SPR EA1N and EA2 PROJECTS

DEADLINE 12 – RESPONSES TO R17 QUESTIONS 18 JUNE 2021

Interested Party: SASES **PINS Refs:** 20024106 & 20024110

Date: 28 June 2021 **Issue:** 1

Figure 1 Potential Sensitive Receptors and Areas Subject to Additional Construction Phase Controls

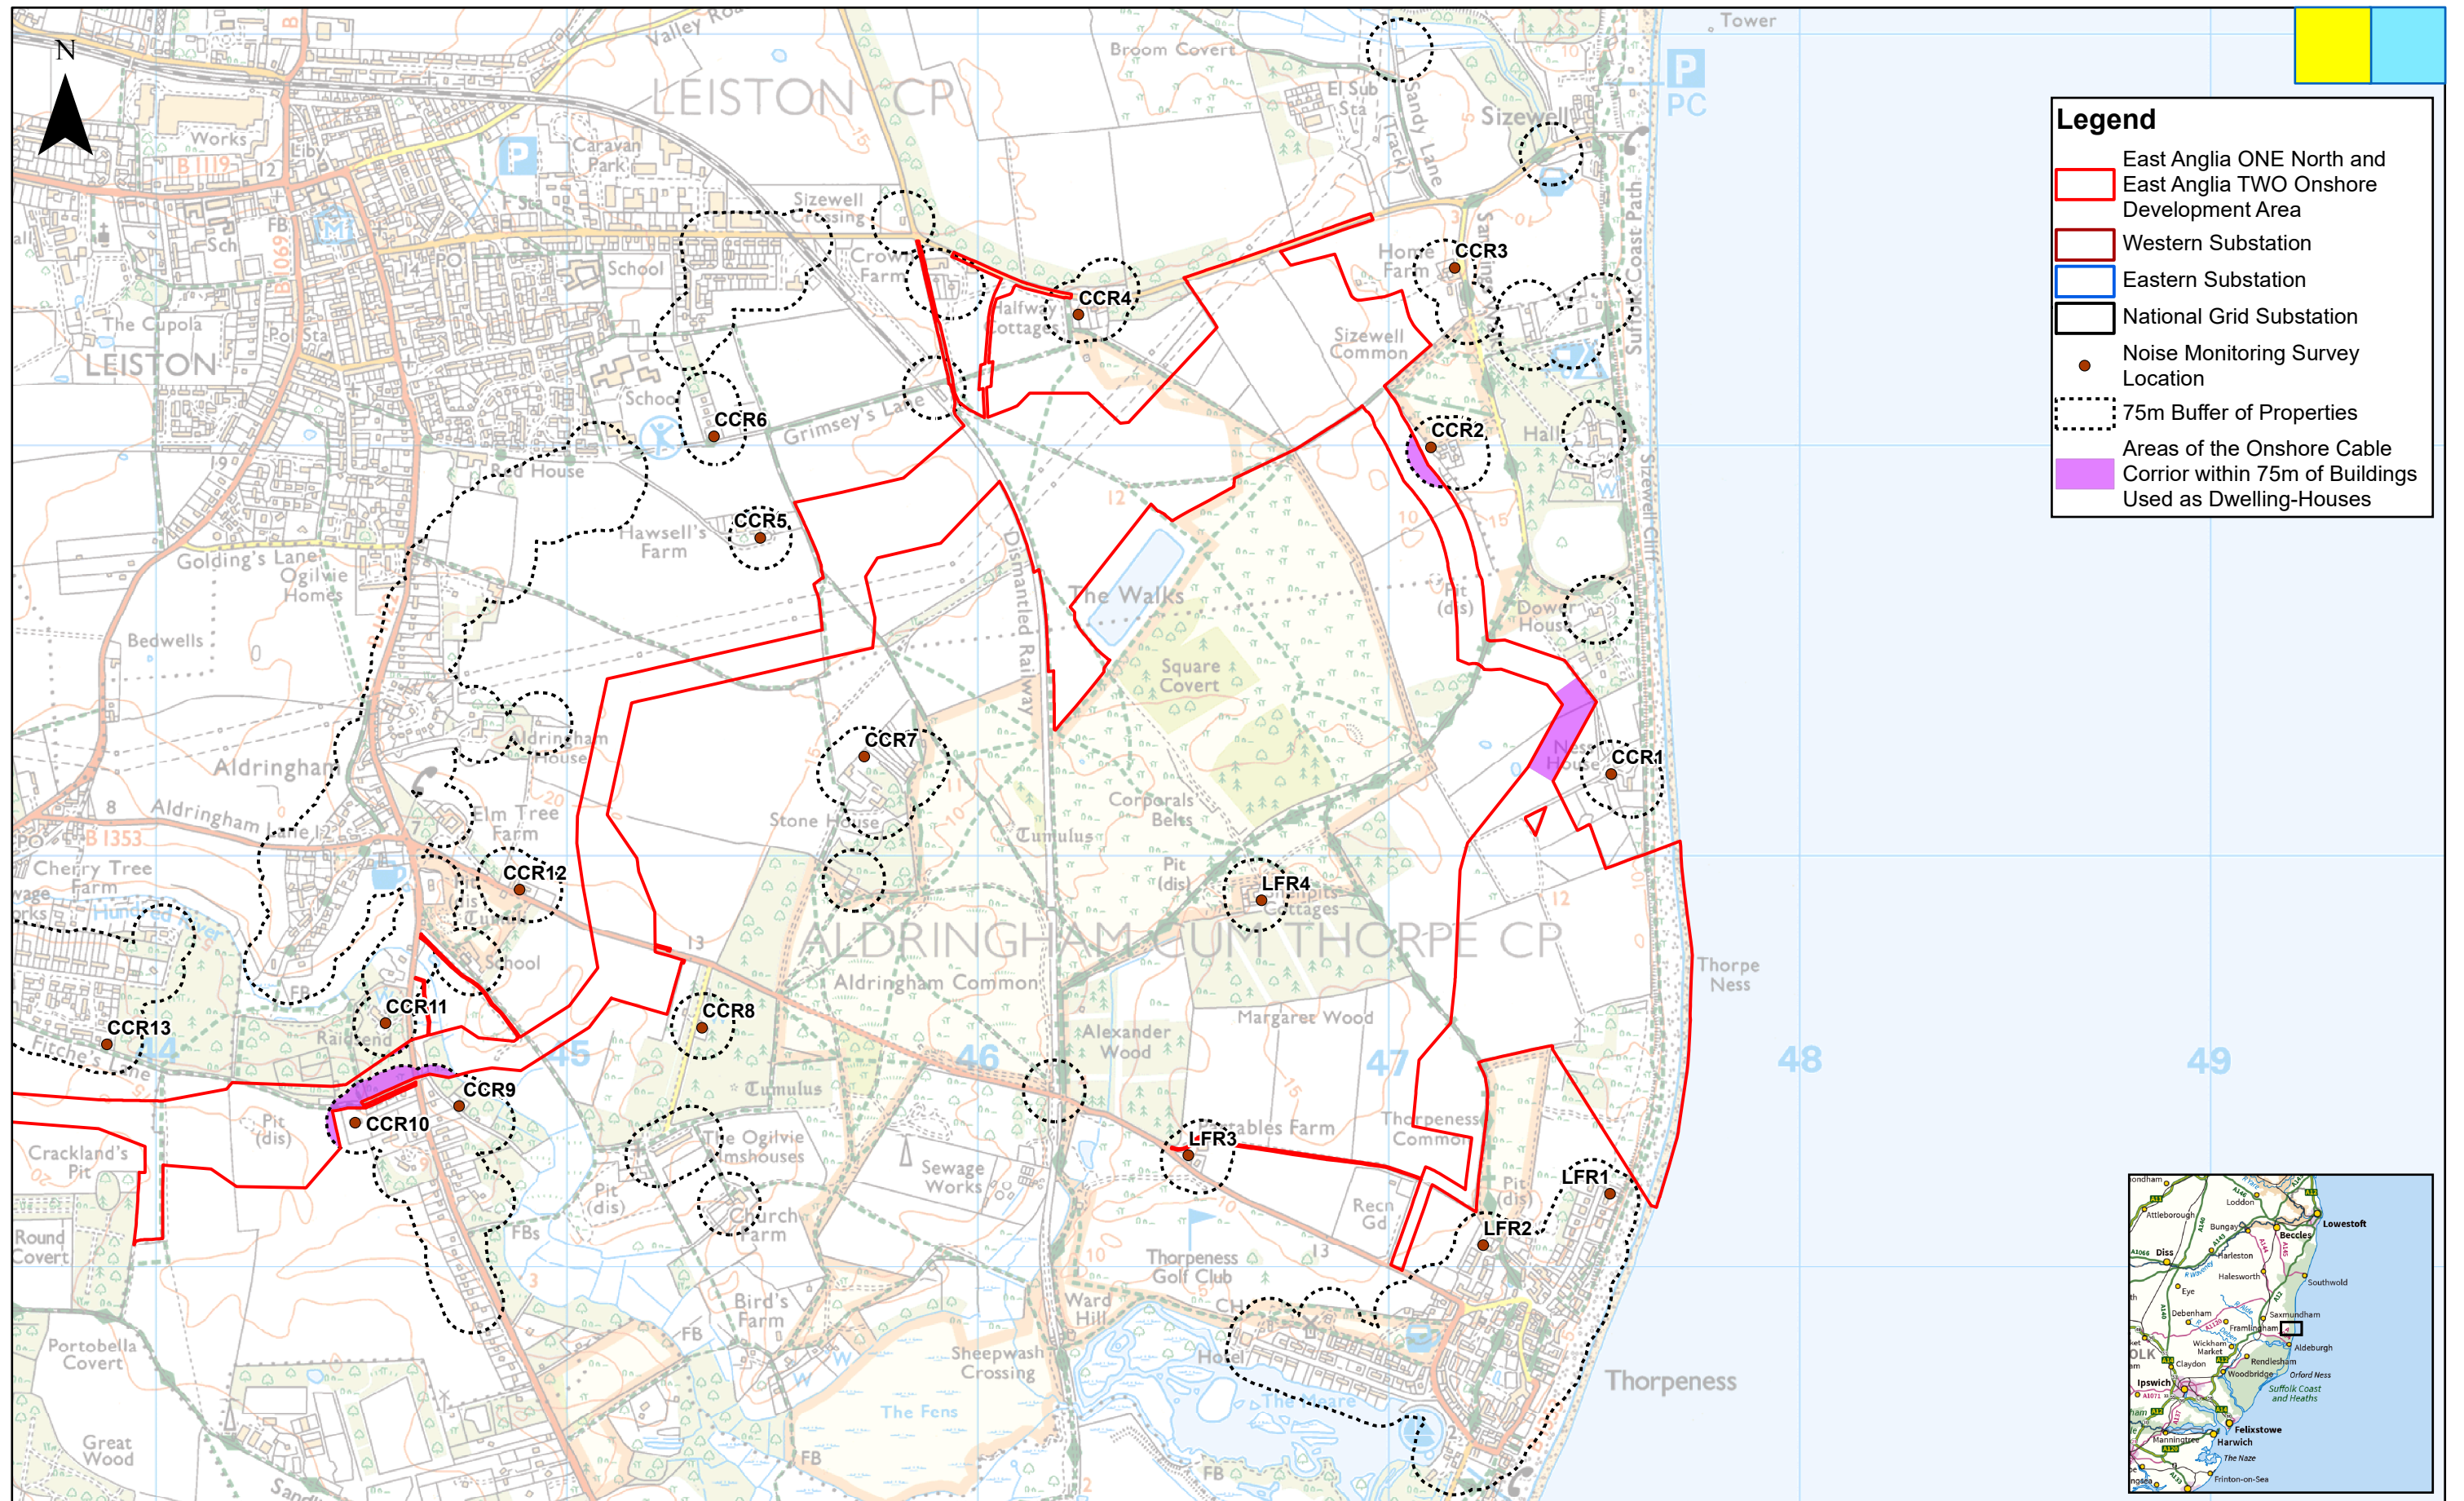
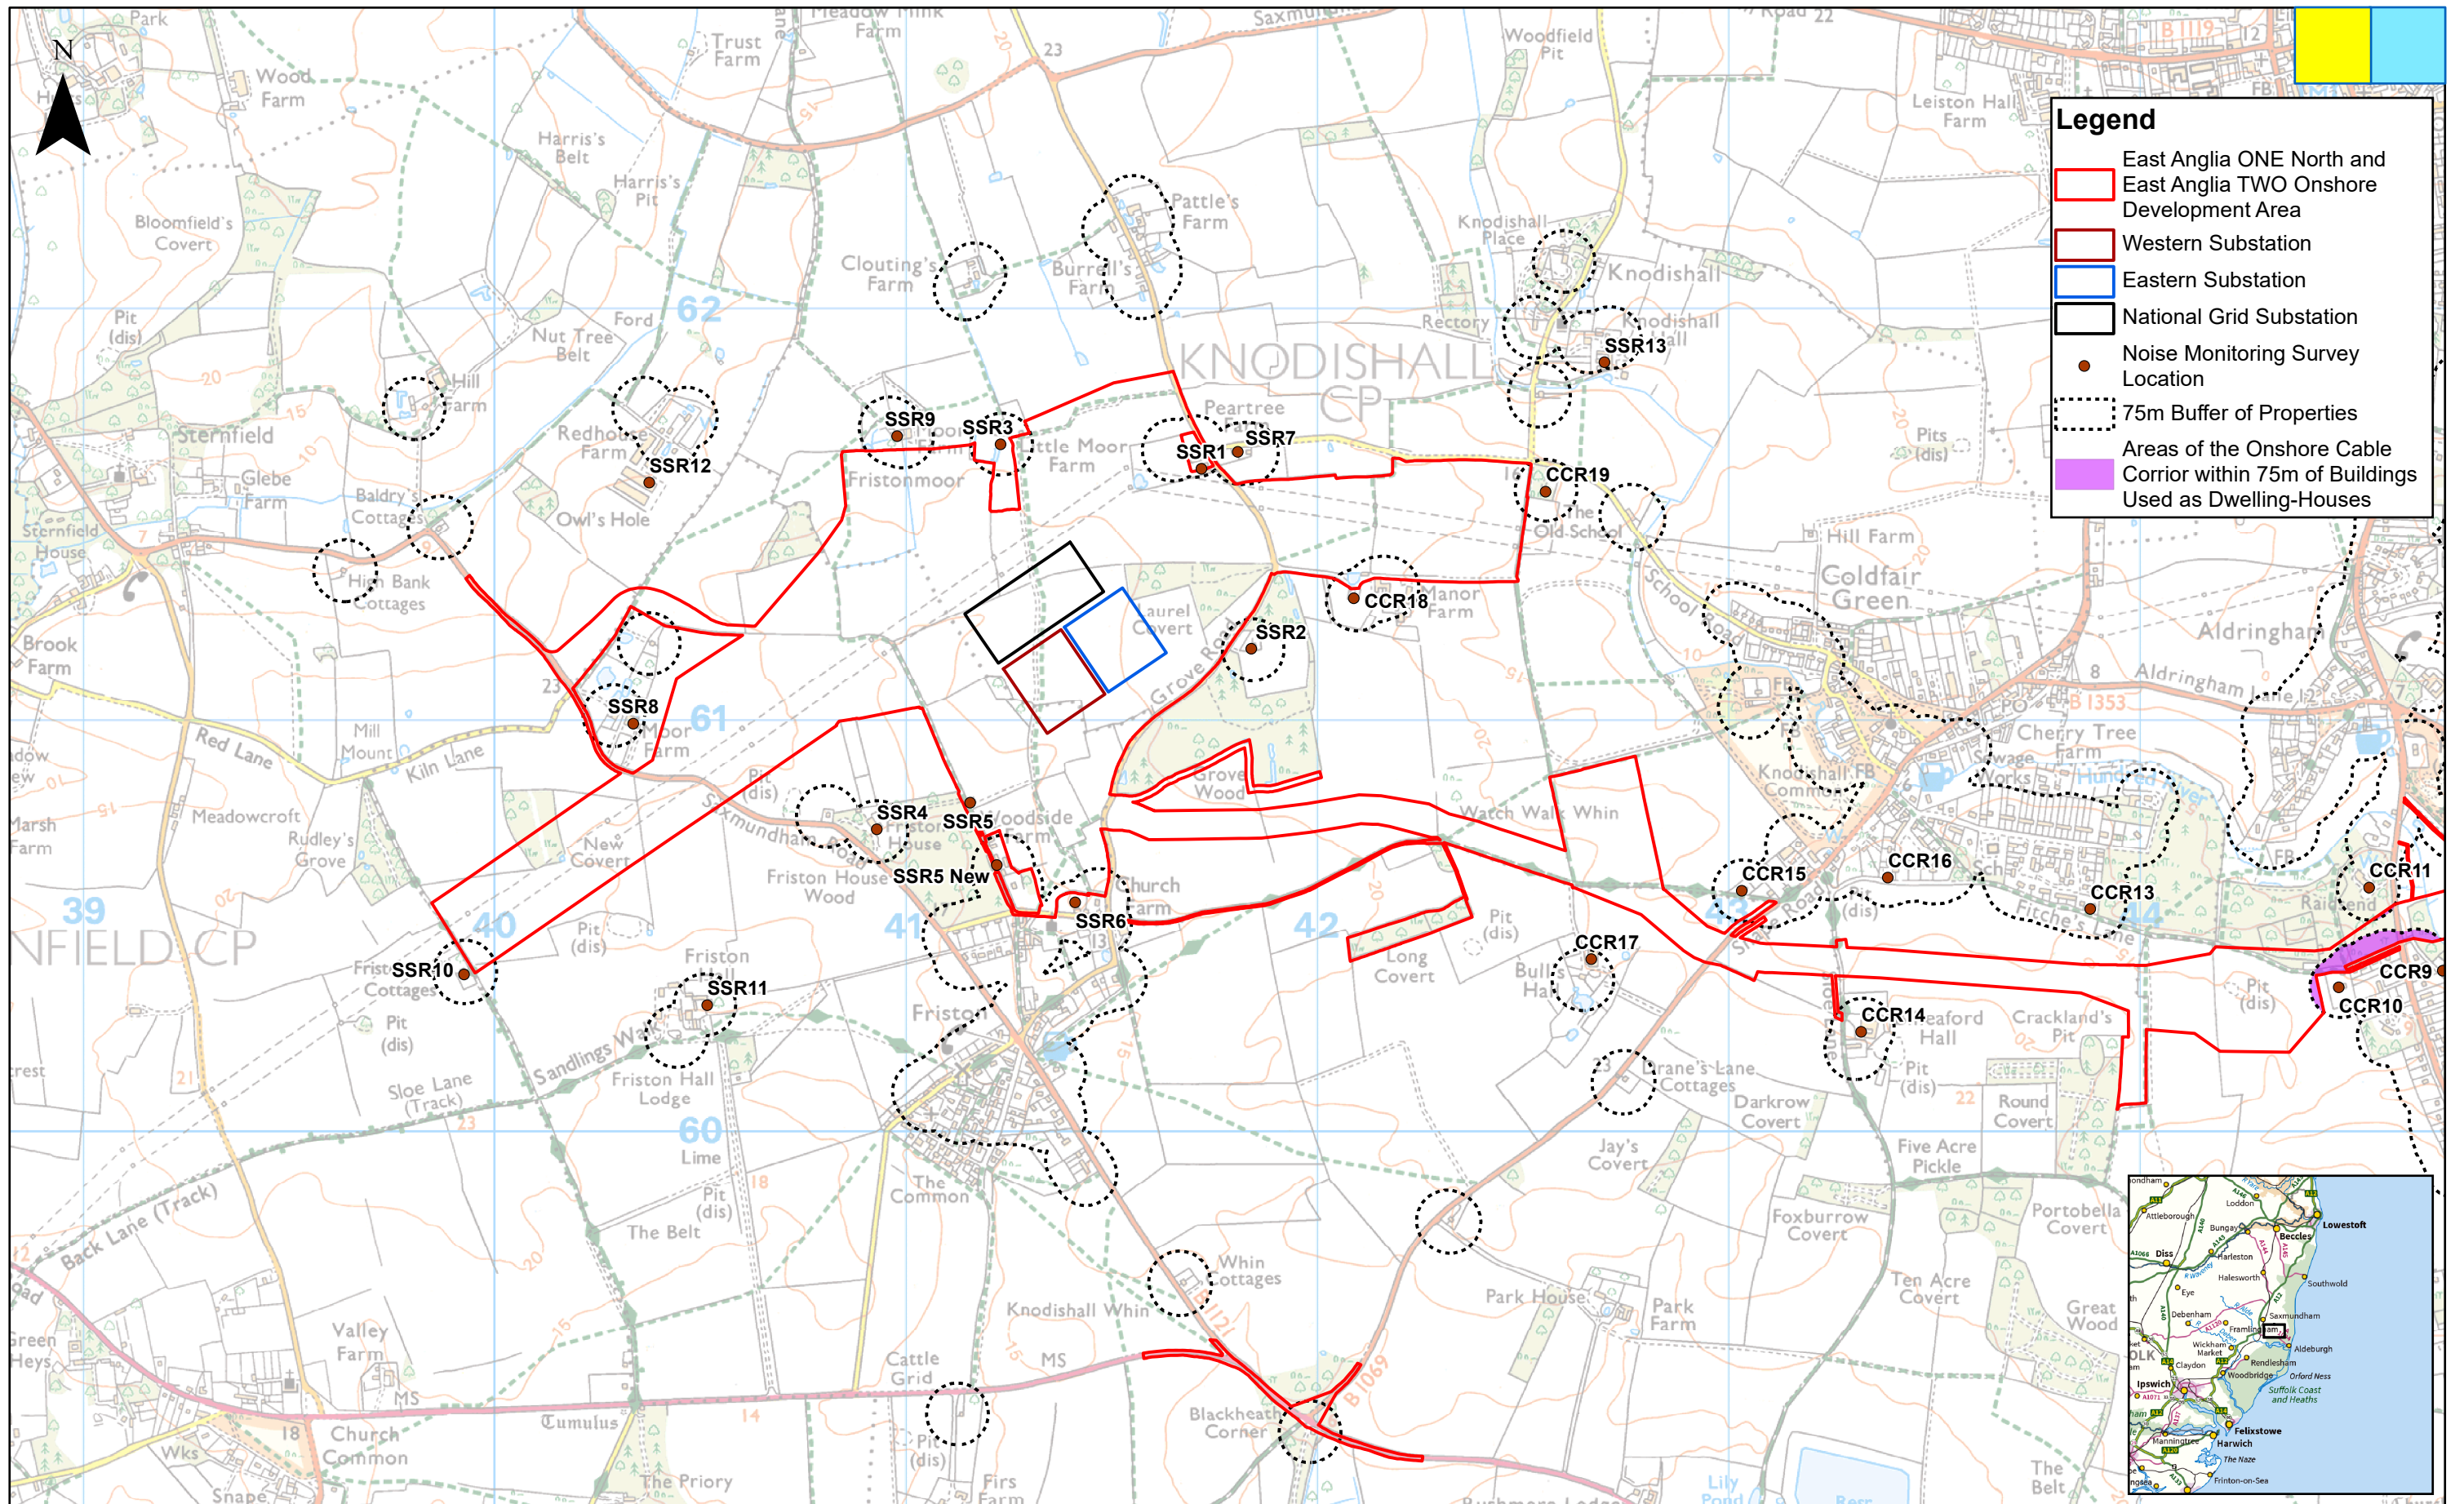
8. The indicative construction surface water drainage scheme illustrated in the Outline Code of Construction Practice is one of few documents submitted by the applicants which gives an impression of the scale of the works associated with the construction of the complex. With regard to the potential impact upon surrounding heritage assets, there is a fundamental contradiction in the submitted application documents between those sections of the Environmental Statements which clearly identify a detrimental impact on heritage assets which will be caused by the construction, operation and decommissioning of the onshore infrastructure, and the applicants' submitted assessments of heritage impacts, which focus only on the impact of the operational phase of the scheme and do not consider the likely impacts which are due to be caused by the construction or decommissioning of the schemes' infrastructure.

9. The construction compounds and construction drainage basins depicted give a clear impression of the larger footprint which the construction phase will occupy, and emphasise that the works will be in much closer proximity to the adjacent heritage assets than the narrow focus on the operational phases suggests. In particular, the southernmost construction drainage basin is in very close proximity to Woodside Farm and the grounds of Friston House, resulting in a greater impact upon the setting of these heritage assets during the construction phase. In their submitted heritage assessments, the applicants have sought to dismiss the construction works as temporary and scoped them out on that basis, but SASSES have consistently stated that the construction phase is due to last for an uncertain period of many years and the proposed working area covers a significantly larger footprint than the operational phase of the proposed schemes. In many cases, the boundaries of the construction area lie in very close proximity to heritage assets, where they will arguably have a much greater impact than some of the later, operational phases of the proposed scheme. This is a clear failure on the part of the applicant to adequately quantify and assess the heritage impacts across the full duration of the scheme.
